Appeal Decision

Appeal Ref: APP/R5510/W/21/3285016

18 West Avenue, Hayes UB3 2EY

PROJECT: Land adjacent to 18 West Avenue, Hayes - UB3 2EY
TITLE: Proposed ground floor and site plan

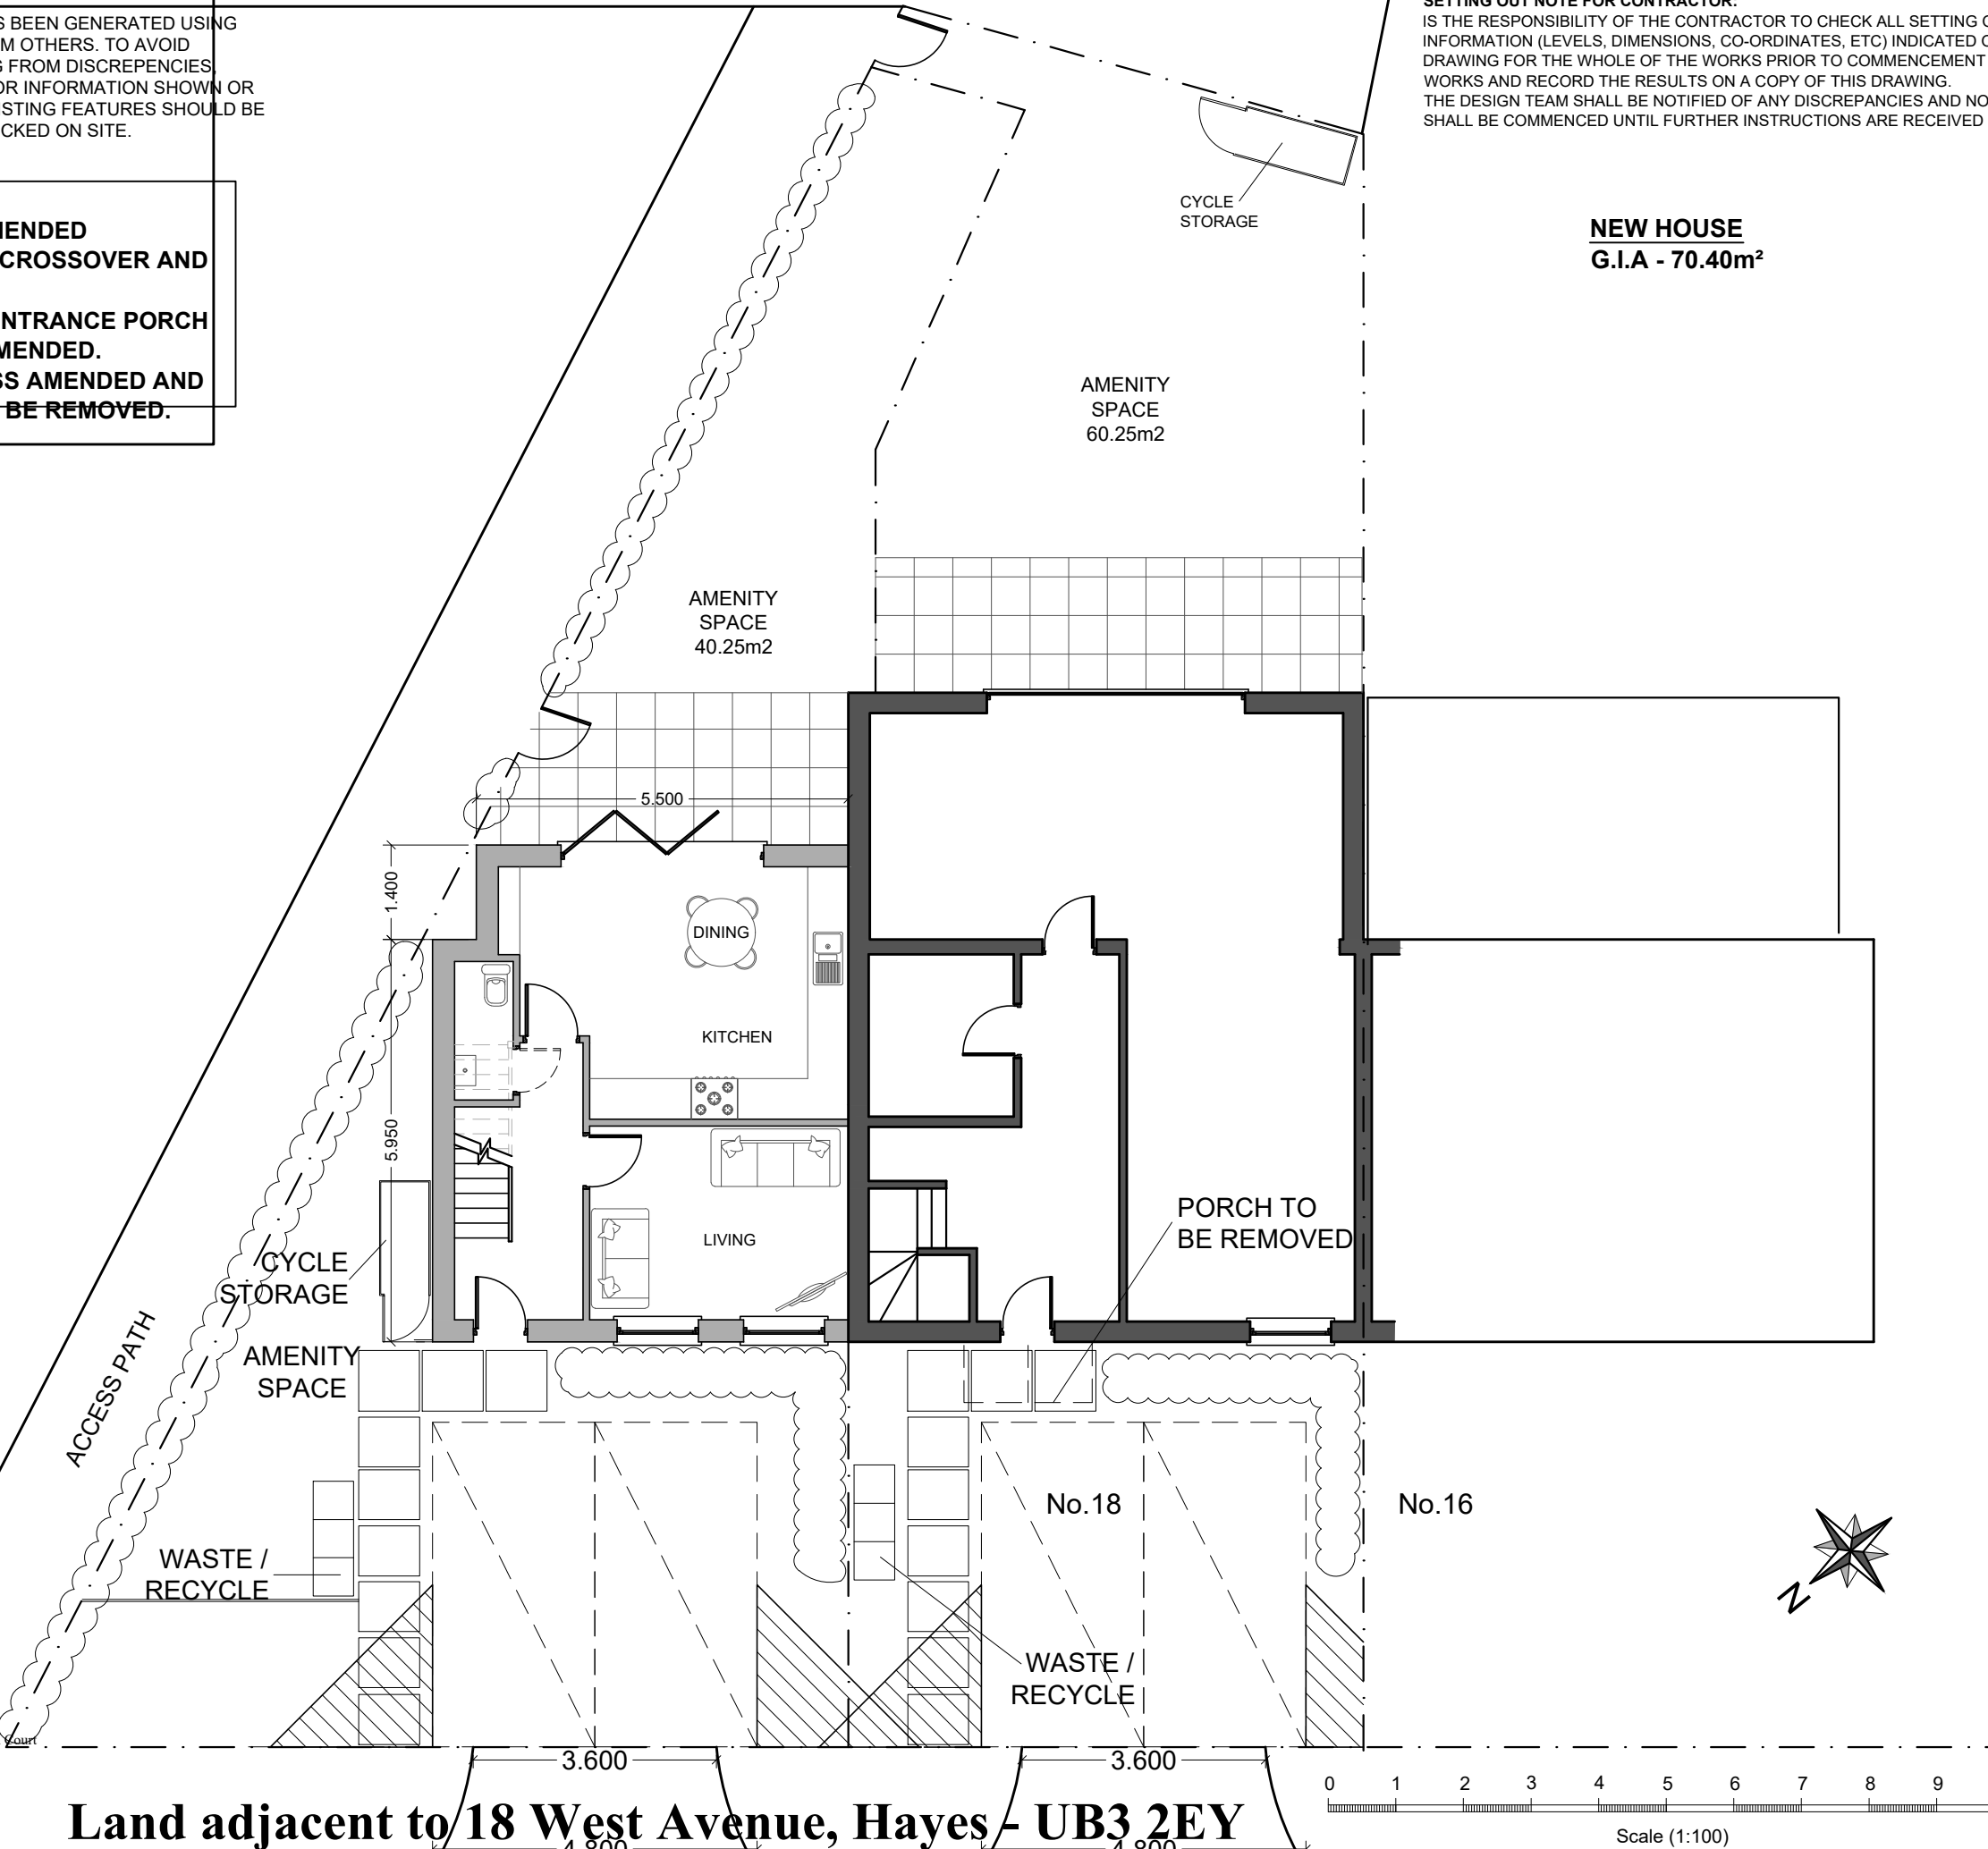
6. Nevertheless, although the proposed dwelling's side elevation would sit comfortably inside the rear building line as defined by 2 Rowan Place, the proposed dwelling would be positioned within a narrow space between its side boundary and No 18. Taking account of the proposed dwelling's width and height, and its very close proximity to the side boundary, the proposed dwelling would appear unduly cramped within the site. The cramped nature of the proposed dwelling would be exacerbated by its prominent position near the junction between West Avenue and Rowan Place. As such, the proposal would cause significant harm to the character and appearance of the area.

8. I observed other nearby examples referenced by the appellant². I note that they demonstrate the principle that new dwellings can, on appropriate sites, acceptability assimilate into the local area. Nevertheless, the constraints of each site and the immediate context are inevitably different to the proposal before me, meaning that the developments referred to are not sufficiently comparable with the proposal so as to change my findings. Although a landscaping strategy could be secured by condition, to enable new shrub planting, this would not overcome the fundamental design deficits identified above.

PROJECT: Land adjacent to 18 West Avenue, Hayes - UB3 2EY
TITLE: Proposed front and rear elevations

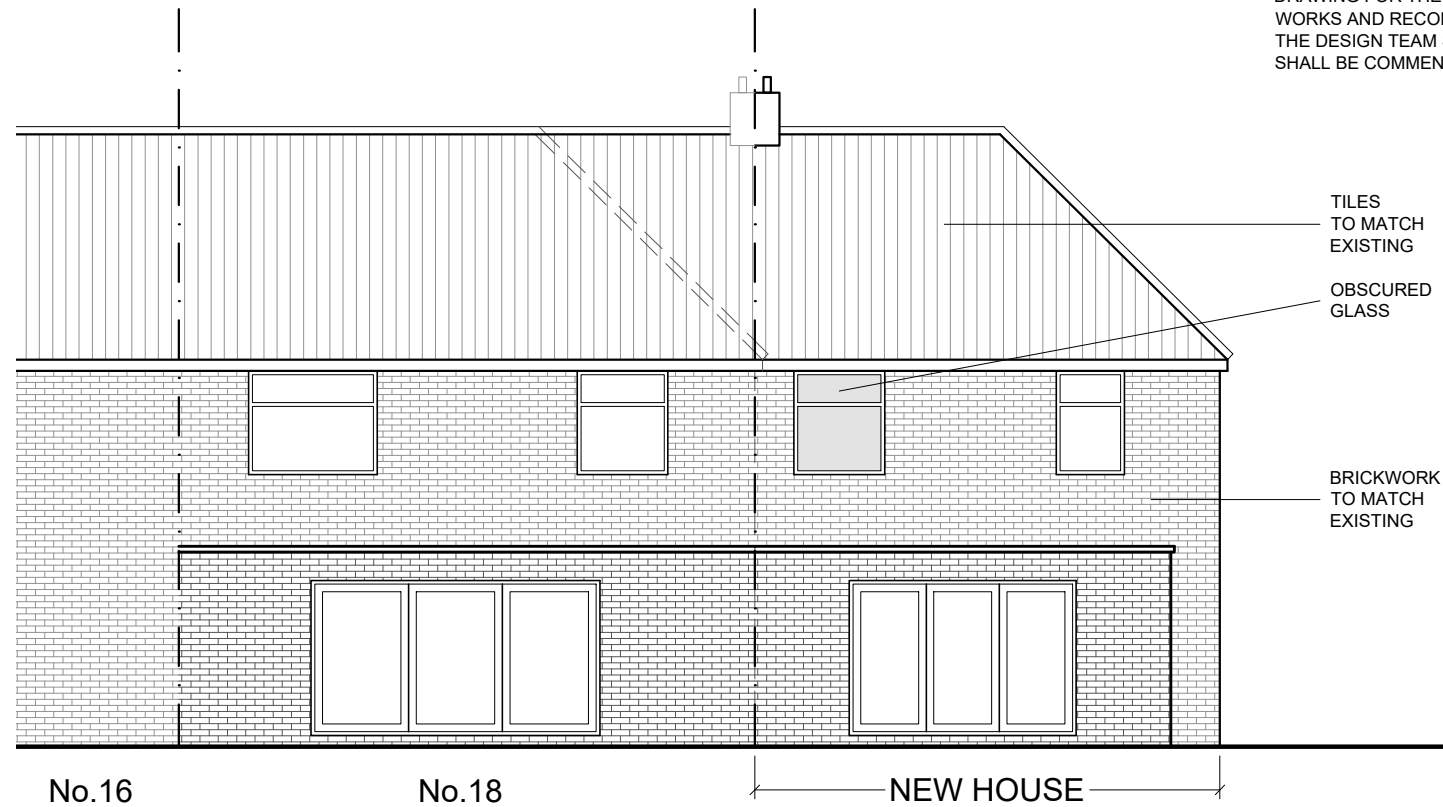
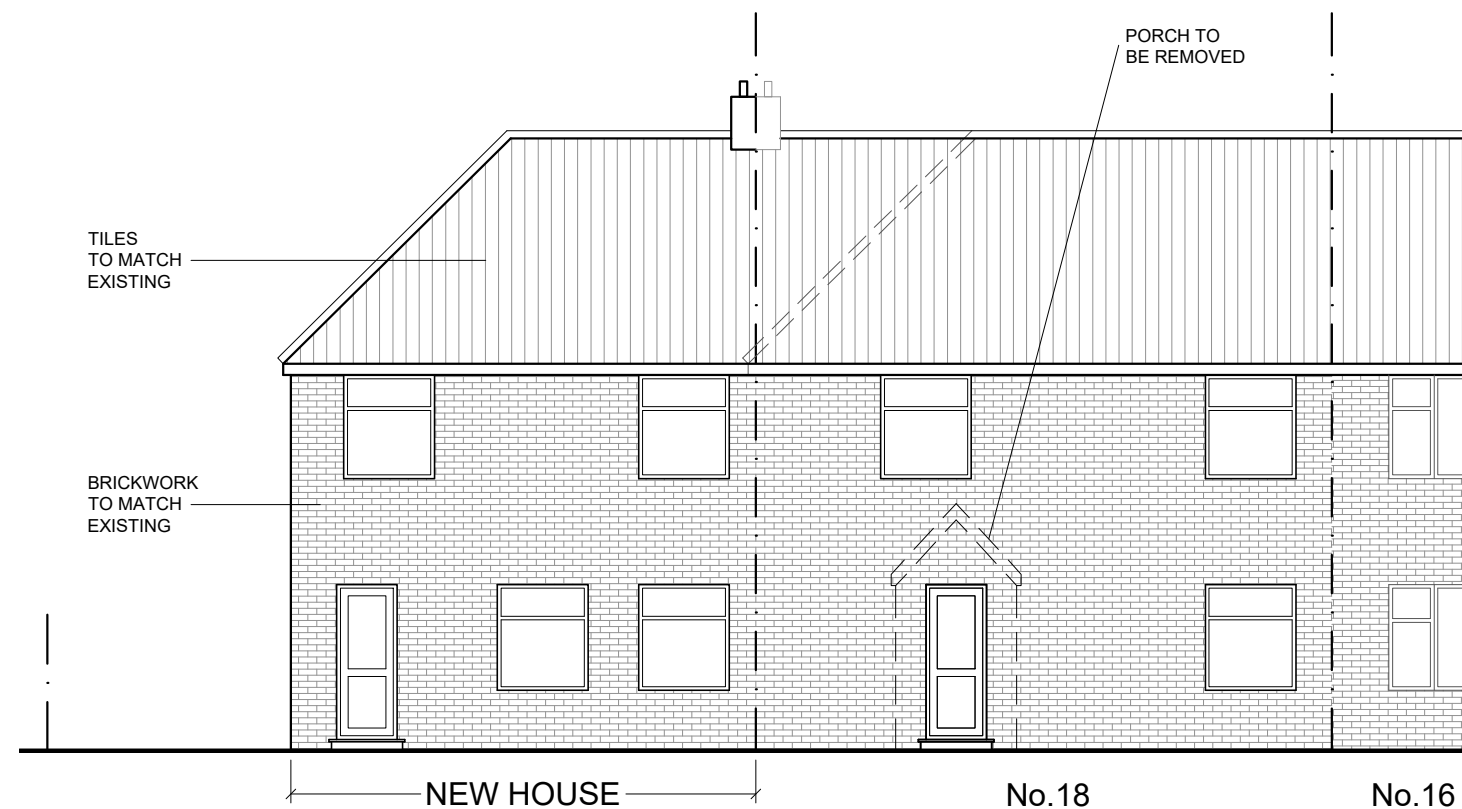
4. In general terms the character of this urban area is changing and evolving over time, and the site is not within or adjacent to a conservation area. The proposal, for the erection of a 2-storey end-of-terrace dwelling to be attached to No 18, would appropriately reflect the design, ridge and eaves level, and materials of No 18. In doing so, it would also broadly mirror the appearance of other properties in the local area. Similarly, the appearance of the proposed hipped roof and the proposed soft landscaping areas would be appropriate for its context.
